From: David Margolis-Pineo
To: Barbara Barhydt; Shukria Wiar
CC: DEVELOPMENT REVIEW GROUP
Date: 5/21/2015 2:21 PM
Subject: Review comment for 185 Fore St.

Memo To: Shukria Wiar
Barbara Barhydt
From: David Margolis-Pineo
Re: 167-185 Fore Street – Review Comments 2014-066
Department of Public Services

(F) BARRIER FREE RAMP DETAILS
N.T.S.

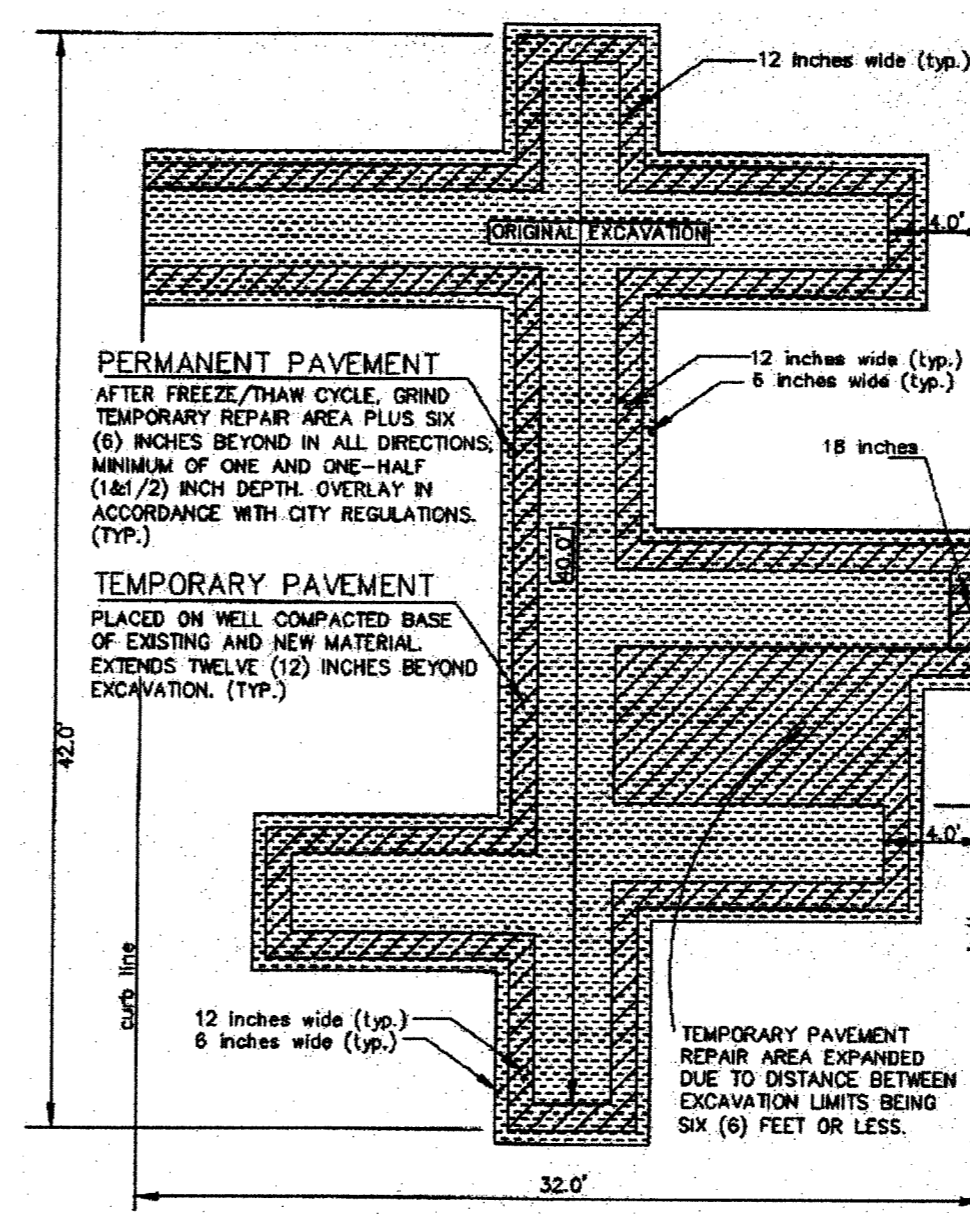
6. All proposed sidewalk crossing ramps shall be constructed to be ADA compliant.
I'm not convinced that the ramp and landing area on the North side of the Fore Street crosswalk has an adequate landing ramp. I am asking Bruce Hyman to further review.

(H) CROSSWALK STRIPING DETAIL
N.T.S.

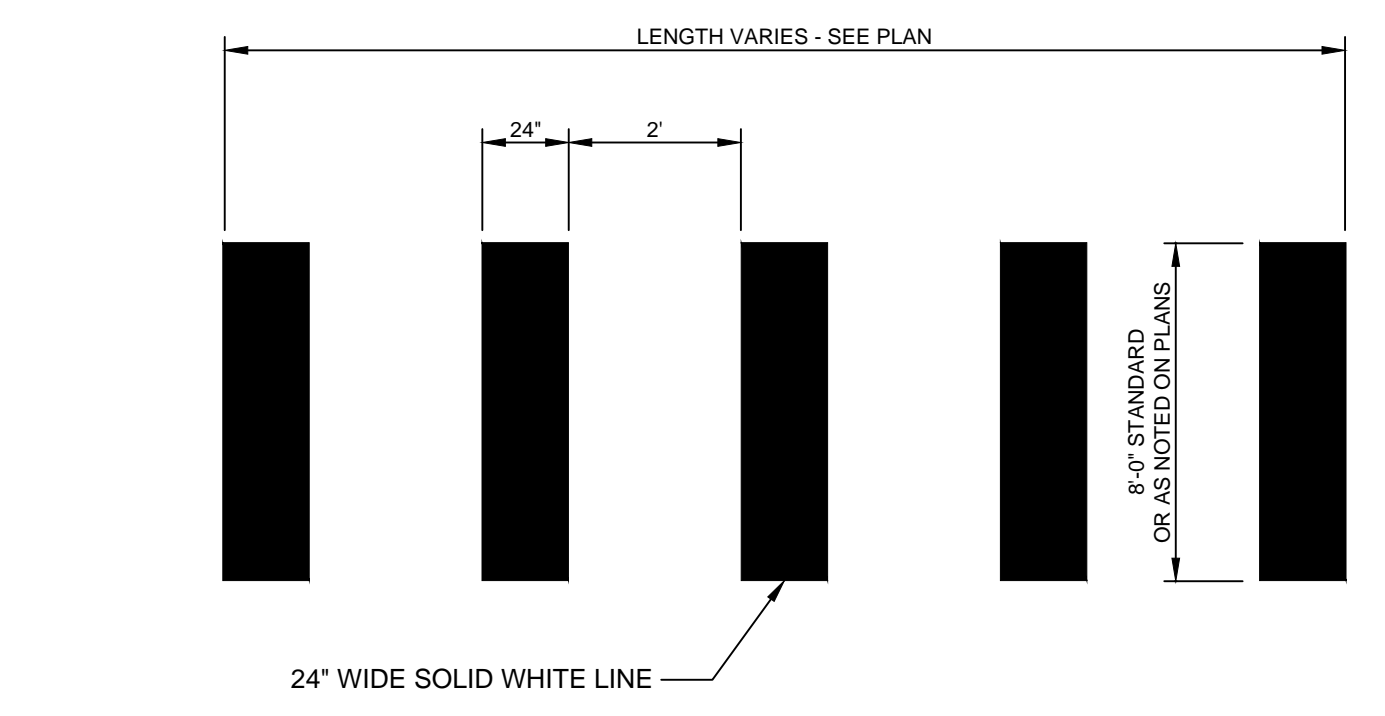
10. Cross walk marking in detail on Sheet C6.2 is incorrect. Please refer to Figure I-22 in the City's Technical Manual.
Crosswalk markings currently show City standard. Thank you
